2023/0463

Change of use of the existing retail shop areas into residential use and associated internal and external alterations to the buildings including removal of shop fronts and demolition of existing outbuildings to create 3no dwellings with gardens and parking area to rear in place of 2no shops and 2no dwellings

163, 165 - 167 Midland Road, Royston, Barnsley, S71 4BZ

Drawing Title. ELEVATIONS
AND SECTIONS
AS PROPOSED

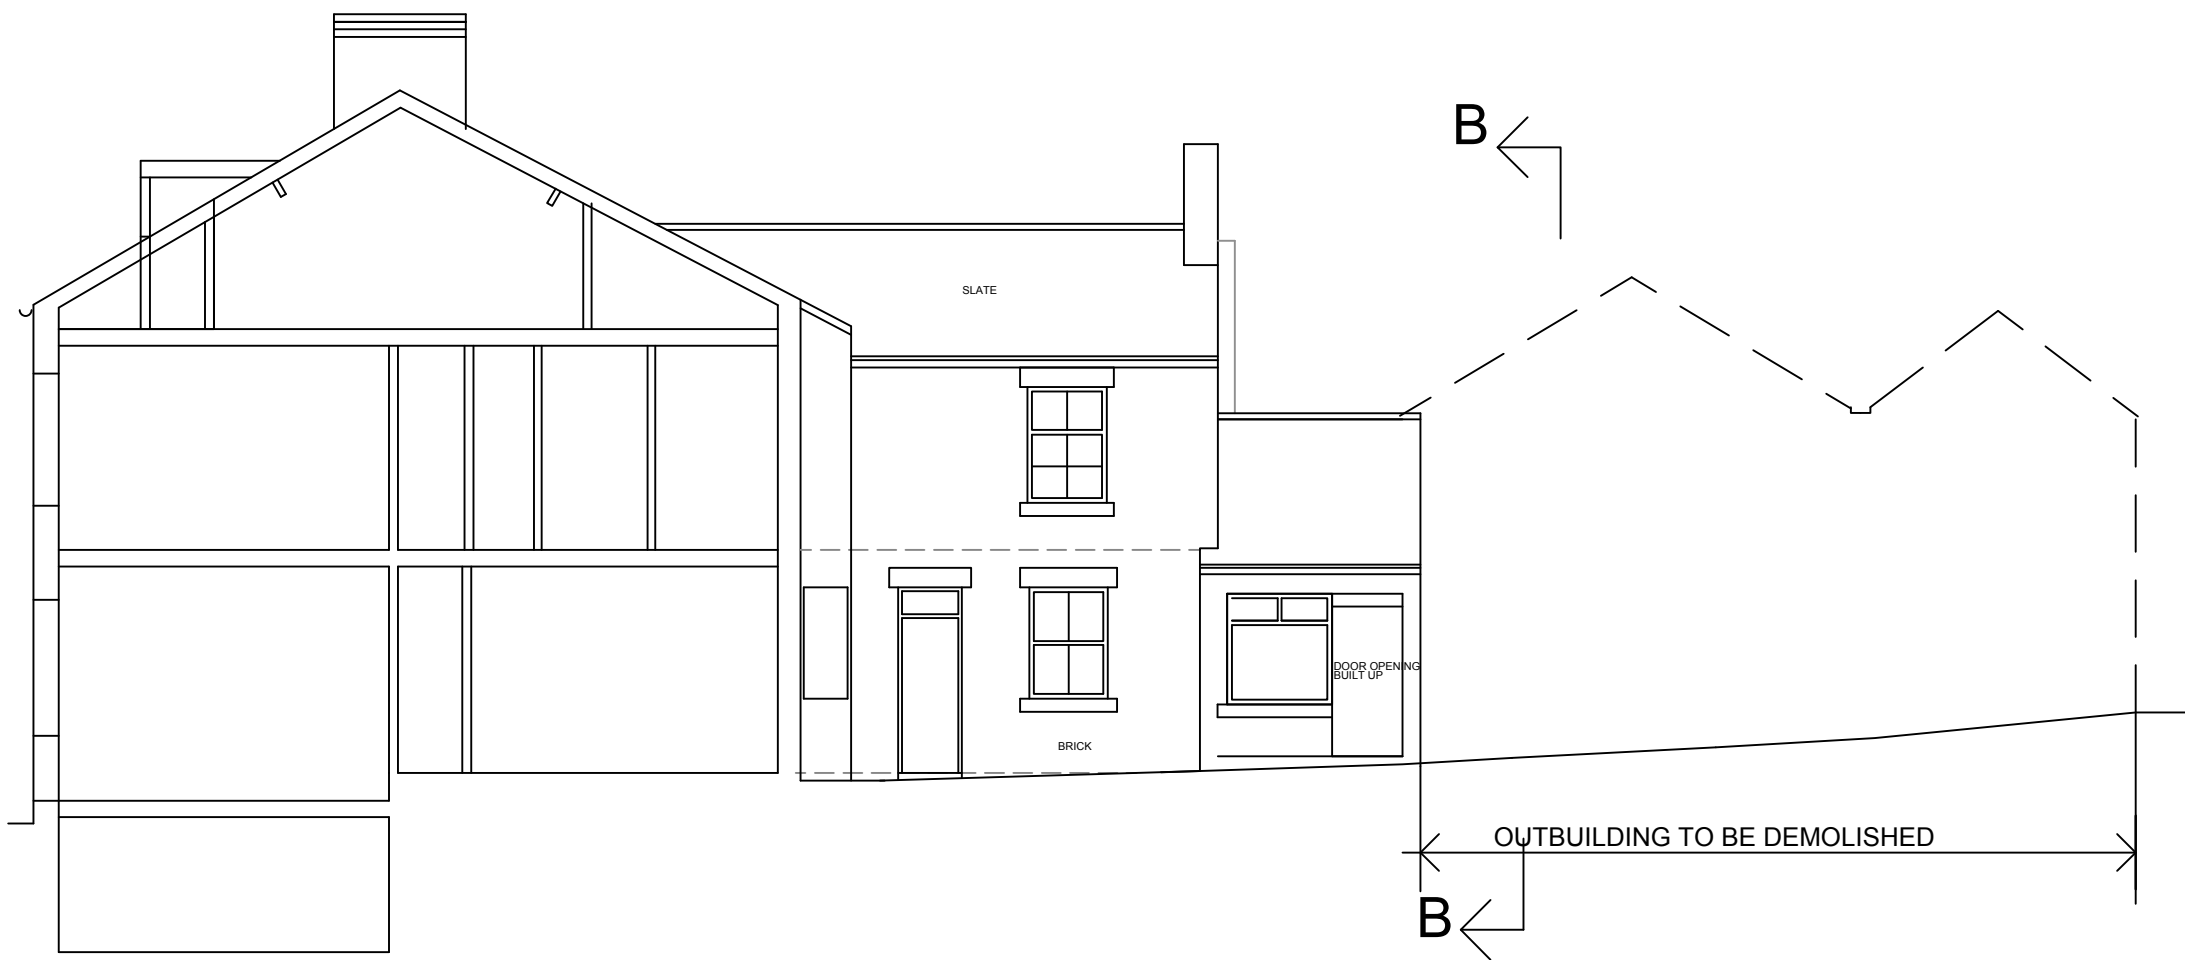
The proposed development primarily covers the internal conversion of the properties to three bedroomed dwellings. However, there are external changes to the buildings with the most visible being the alterations to the respective frontages of the ground floors of the properties. Specifically, the shopfront details will be removed, with the cavity filled with a rendered finish and domestic fenestration details added. The domestic fenestration of each plot includes the installation of a three-panelled window and a main access door, both UPVC. These details are in keeping with the surrounding area which is characterised by a mixture of render, red brick and stone. The agent has agreed to a condition which requires details of the external materials to be submitted upon commencement and agreed by the LPA.

The other external changes are in relation to minor details such as obscure glazing to windows and the increase of the size of the first-floor rear-facing window on no. 165, which are both to include functionality of the proposed units. Boundary treatments will be added to the rear external areas of the units, with details confirmed at a later stage through a condition. Additionally, c.1m high metal fencing will be added to the frontages of each respective plot to provide separation between the front elevations of the dwellings and to ensure that the development is similar to the surrounding area in terms of character.
